Response to Planning application from Hertfordshire County Council (T and CP GDP Order 2015)

District ref: 6/2021/3422/MAJ
HCC ref: WH/11241/2022
HCC received: 10 June 2022
Area manager: Matthew Armstrong
Case officer: Chris Carr

SALISBURY SQUARE HATFIELD AL9 5AD

AMENDED PROPOSAL

CLIENT: GASCOYNE ESTATES
JOB: SALISBURY SQUARE HATFIELD AL9 5AD
DRAWING TITLE: PROPOSED REFUGE AND CYCLE STORE
SCALE: 1:100 @ A2
DATE: NOVEMBER 2021
STATUS: PLANNING
DRAWING NUMBER: 789 - PL - 080
REV: FF
ISSUED BY: FF

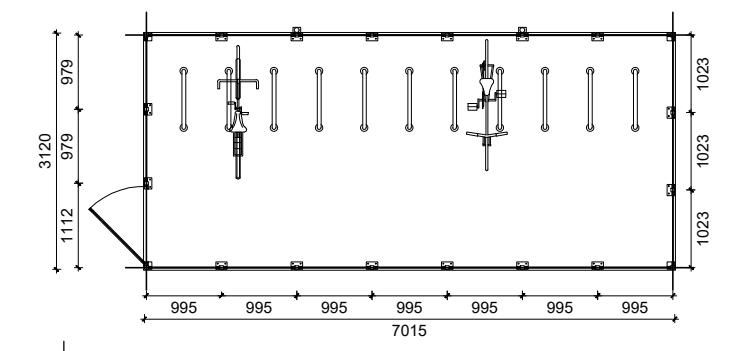
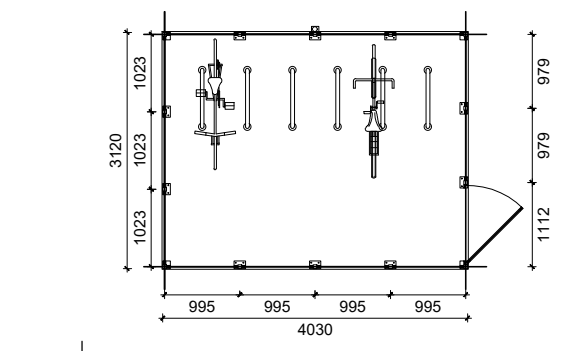
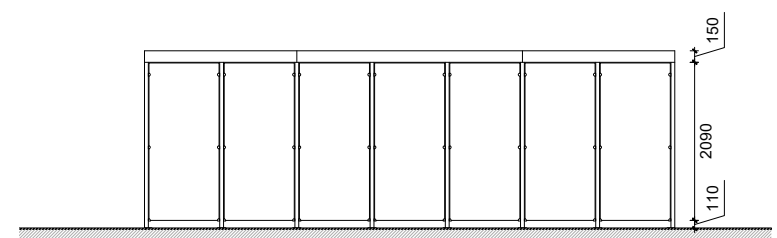
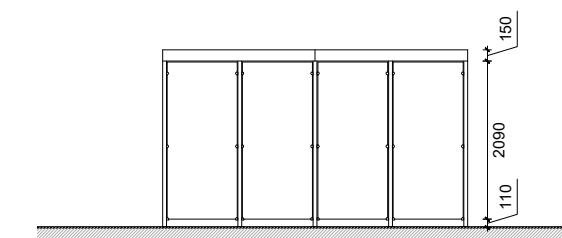
This statement and drawing 789 - PL - 080 - B - Proposed Refuse and Cycle stores have been submitted in response to HCC's refusal due to "further information of cycle parking is required in line with the Cycle Infrastructure Design Guide".

According to LTN 1/20 5% of cycle spaces should be suitable for non-standard cycles to accommodate individuals with mobility impairments.

Drawing 789 - PL - 080 - B - Proposed Refuse and Cycle stores shows one space of 2000mm (length) by 1000mm (width) for adapted cycles (marked by the wheelchair) in the two covered cycle stores.

The proposed cycle stores have been lengthened in order to provide space for mobility scooters.

CLIENT: GASCZYNE ESTATES  
 JOB: SALISBURY SQUARE HATFIELD AL9 5AD  
 DRAWING TITLE: PROPOSED SITE PLAN GROUND FLOOR LEVEL  
 SCALE: 1:250 @ A1 / 1:500 @ A3  
 DATE: NOV 2021  
 STATUS: PLANNING  
 DRAWING NUMBER: 789 - PL - 109 C  
 REV: C  
 ISSUED BY: SR

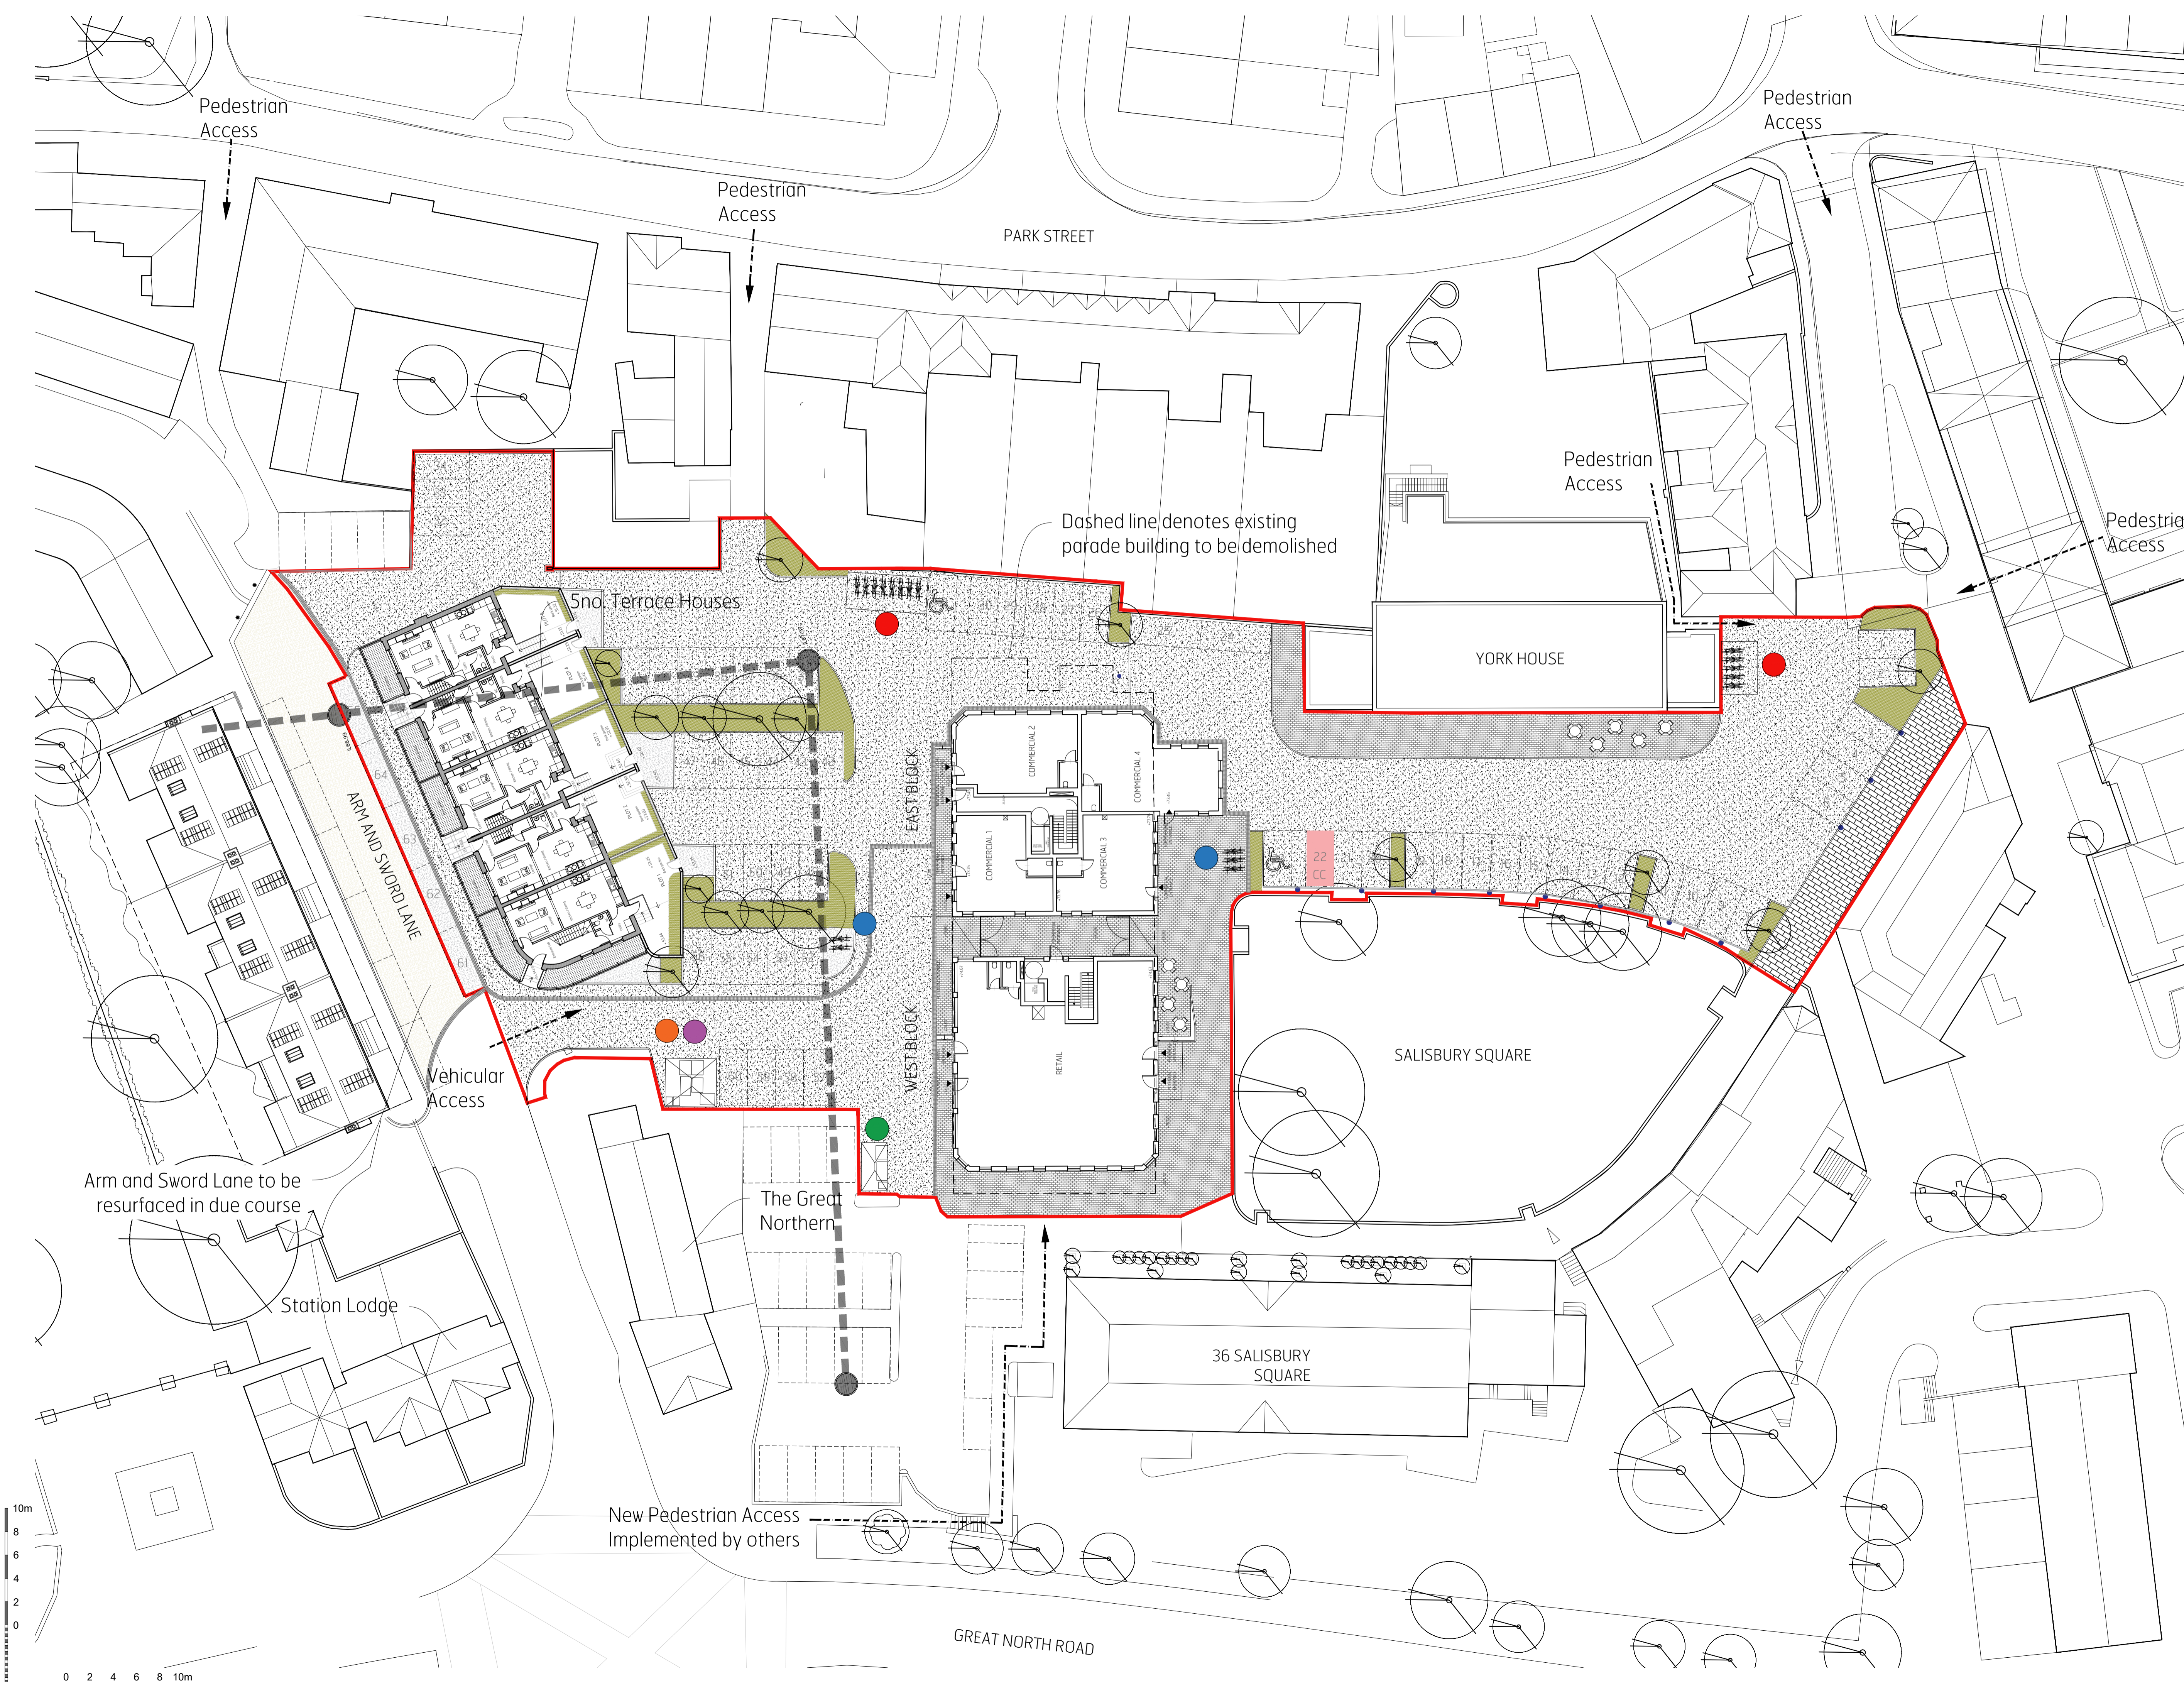
One of the reasons the proposal was recommended to be refused by HCC was as details were omitted regarding Electric Vehicle Charge Point provision.

The statement included in the covering letter states that 20% of the car parking spaces will have EV charging points. This means that at least 13 of the 65 car parking bays must be served by an active EV charging point.

This is supported by the 789 - PL - 109 - E - Proposed site plan ground floor level drawing. Which shows 11 EV charging points near 21 parking bays to the southeast of the site. These 21 parking bays include 1 disabled bay and 1 car club bay.

EV charging points will be provided to 20% of the car parking spaces and the rest of the spaces will have passive infrastructure for EV charging in future.

DRAWING NUMBER: 789 - PL - 150 REV: C ISSUED BY: SR

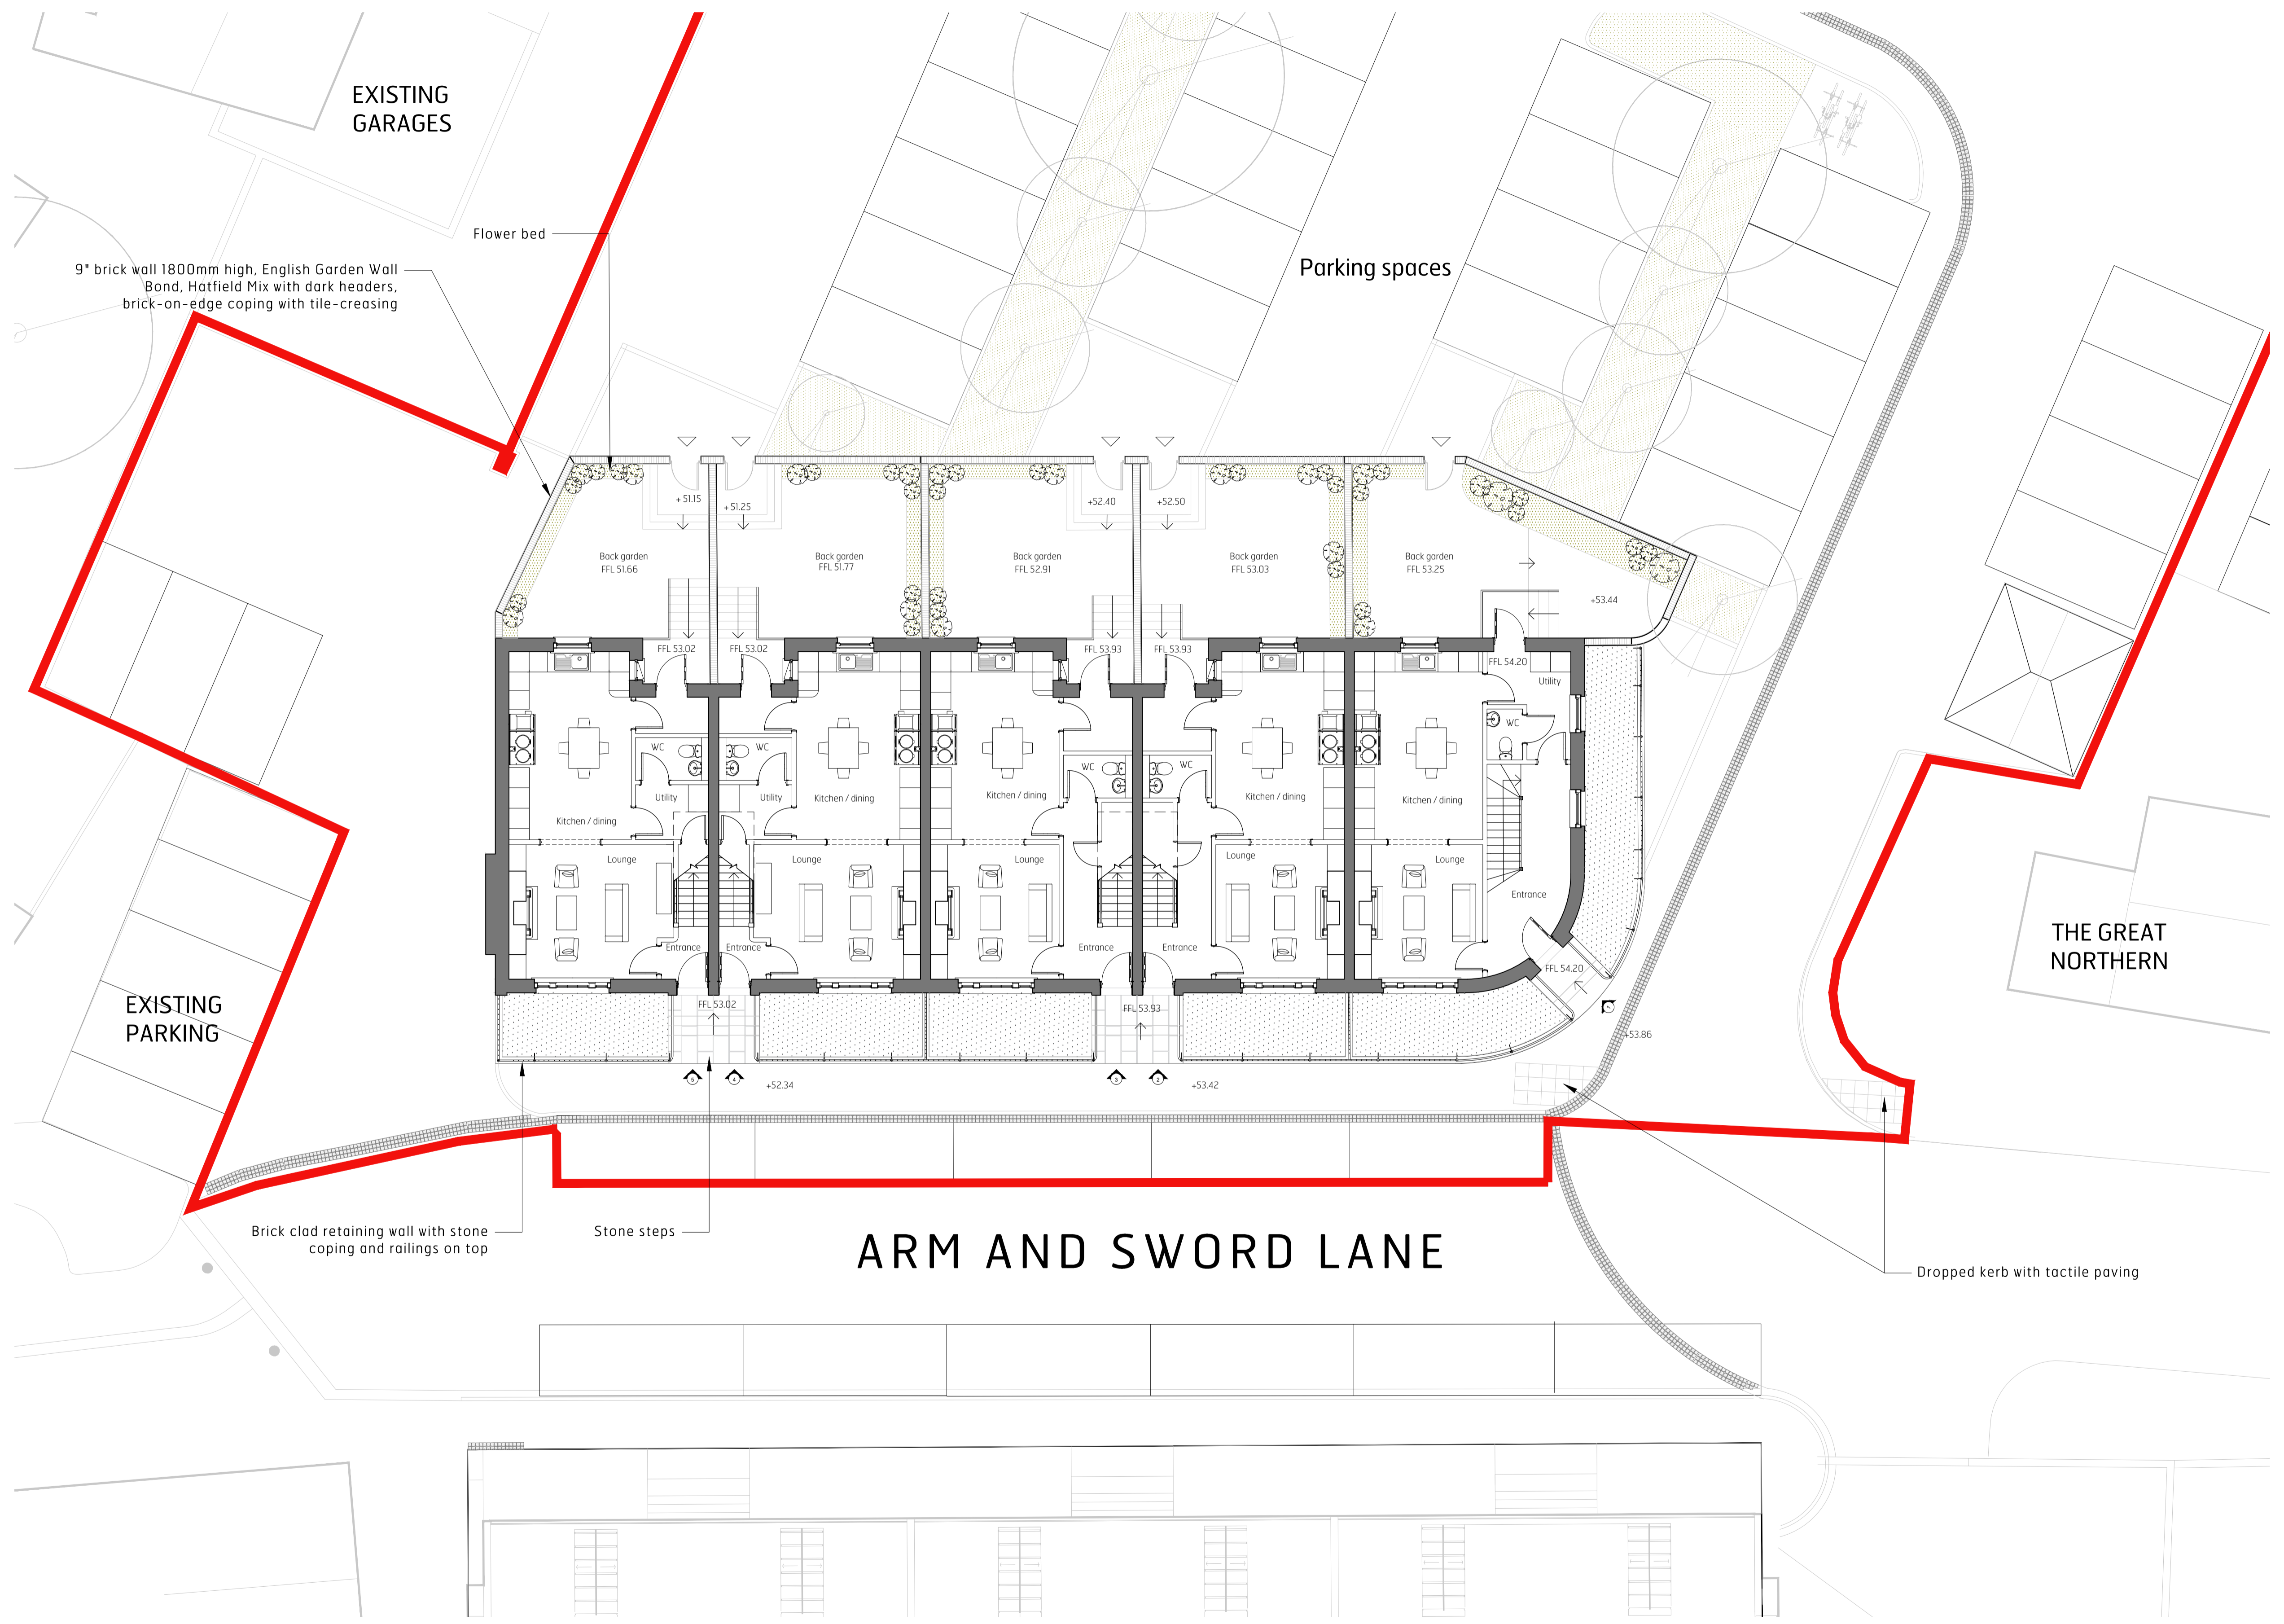
Drawing 789 - PL - 150 - C - Houses Ground Floor (called Proposed Ground Flood Plan in the drawing) shows "dropped kerb with tactile paving" on either side of the vehicular access from Arm And Sword Lane.

The access into the site from Arm & Sword Lane includes for dropped kerbs/tactile paving see drawings).
